**From:** Jeff Senior <[REDACTED]>  
**Sent:** Thursday, 13 December 2018 4:19 PM  
**To:** Keith Ng  
**Cc:** Peter Lay  
**Subject:** HPE CM: F6 Submission from Canterbury Bankstown Council  
**Attachments:** Scan\_161614.pdf

The submission concerns the route of the electricity supply to the project.

Figure 6-14 Permanent power supply route

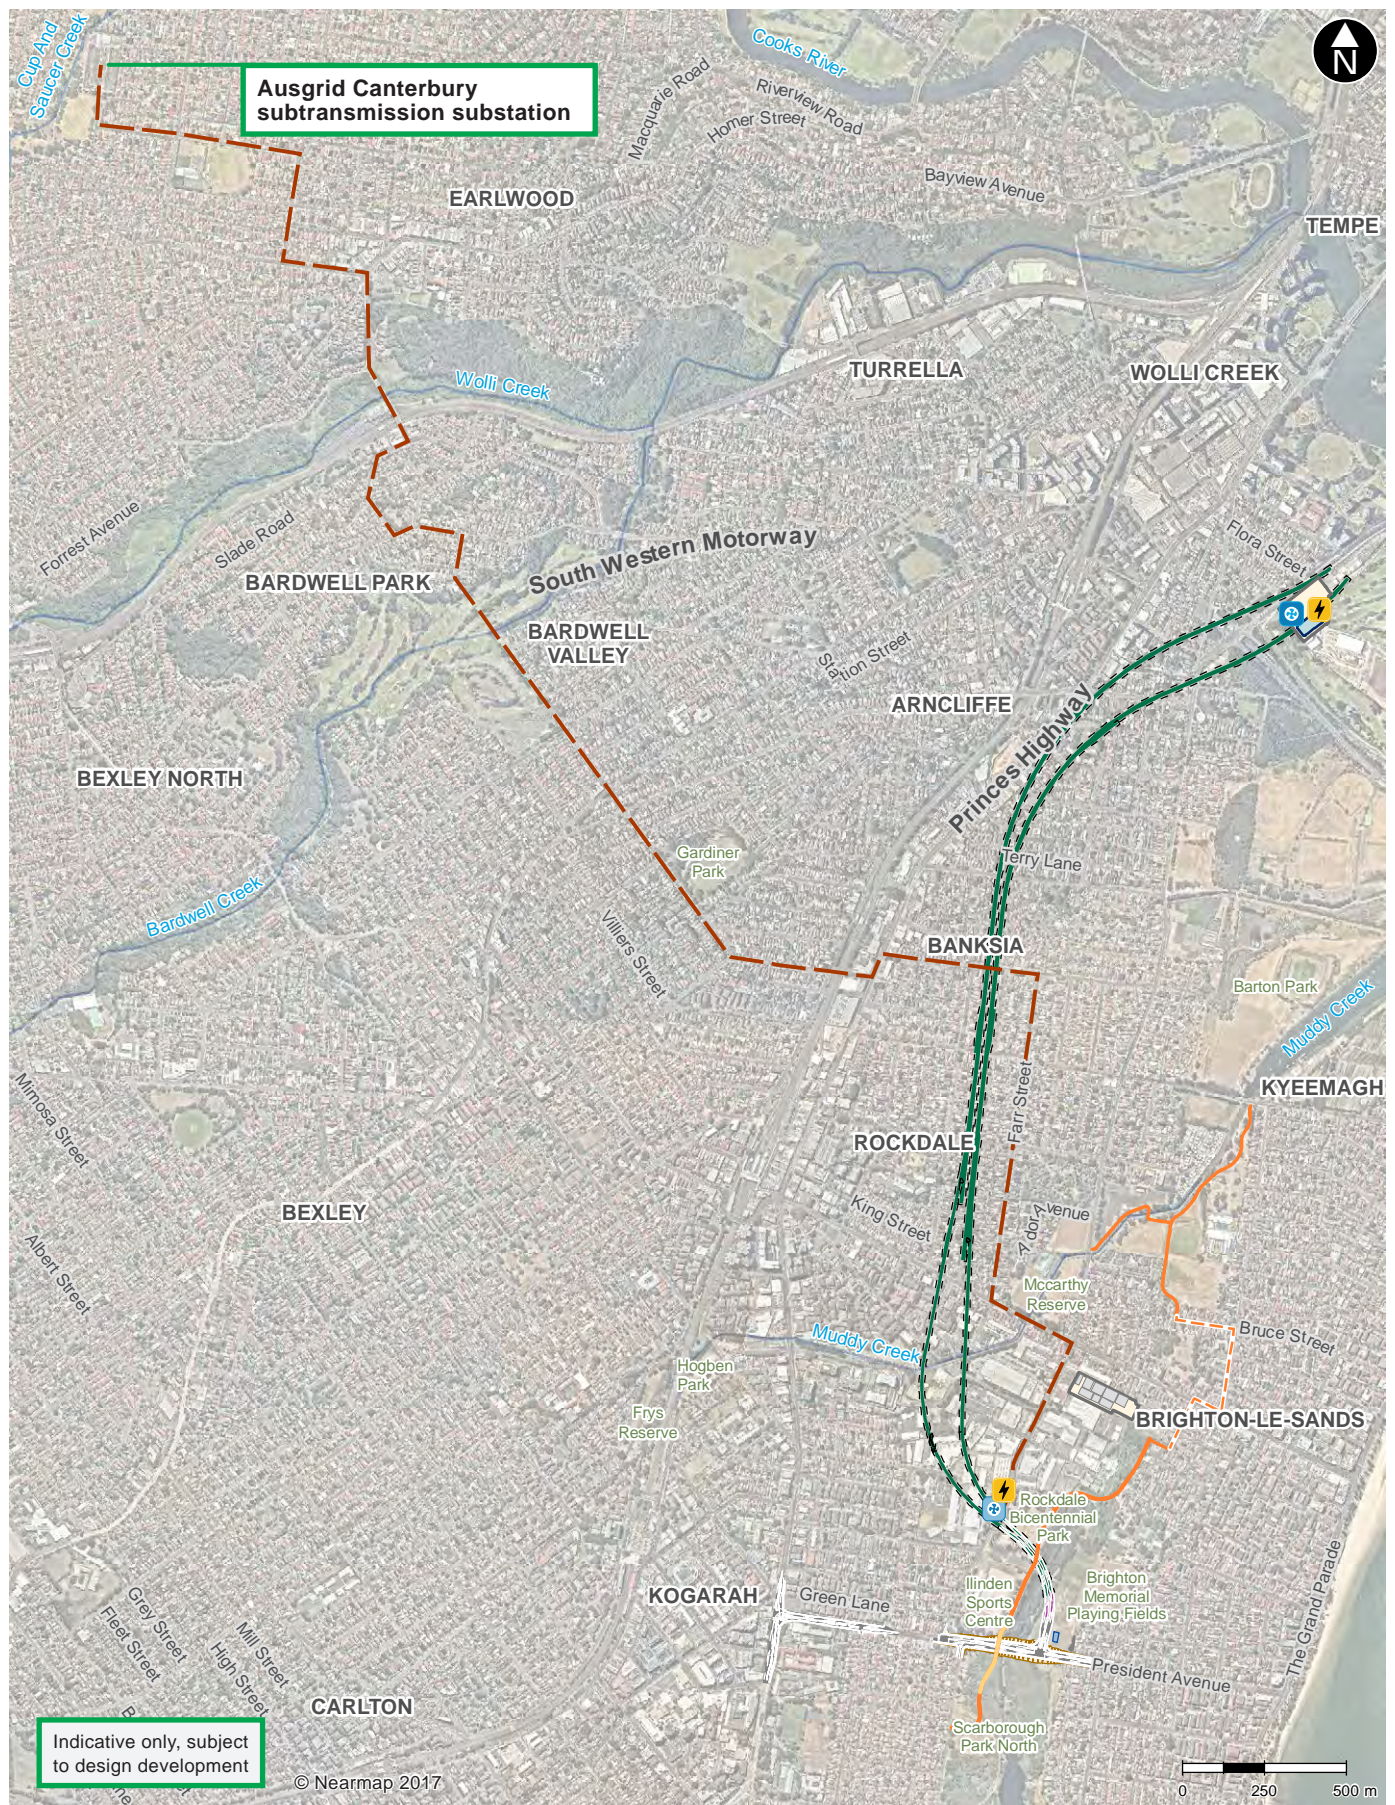
Council proposes 2 options to the proposed route.

Option 1. Via

Westfield, William, Hood, Homer, Matilda Bray on to Hartill Law to the Proposed route

Option 2 is to utilise the electrical feed to the Bexley MOC and head to West Botany MOC3, if there is capacity. This could be via Bexley Road

## Recommended option 2

\* From Bexley MOC  
to West Botany MOC3  
if there is capacity

33 kV or Greater
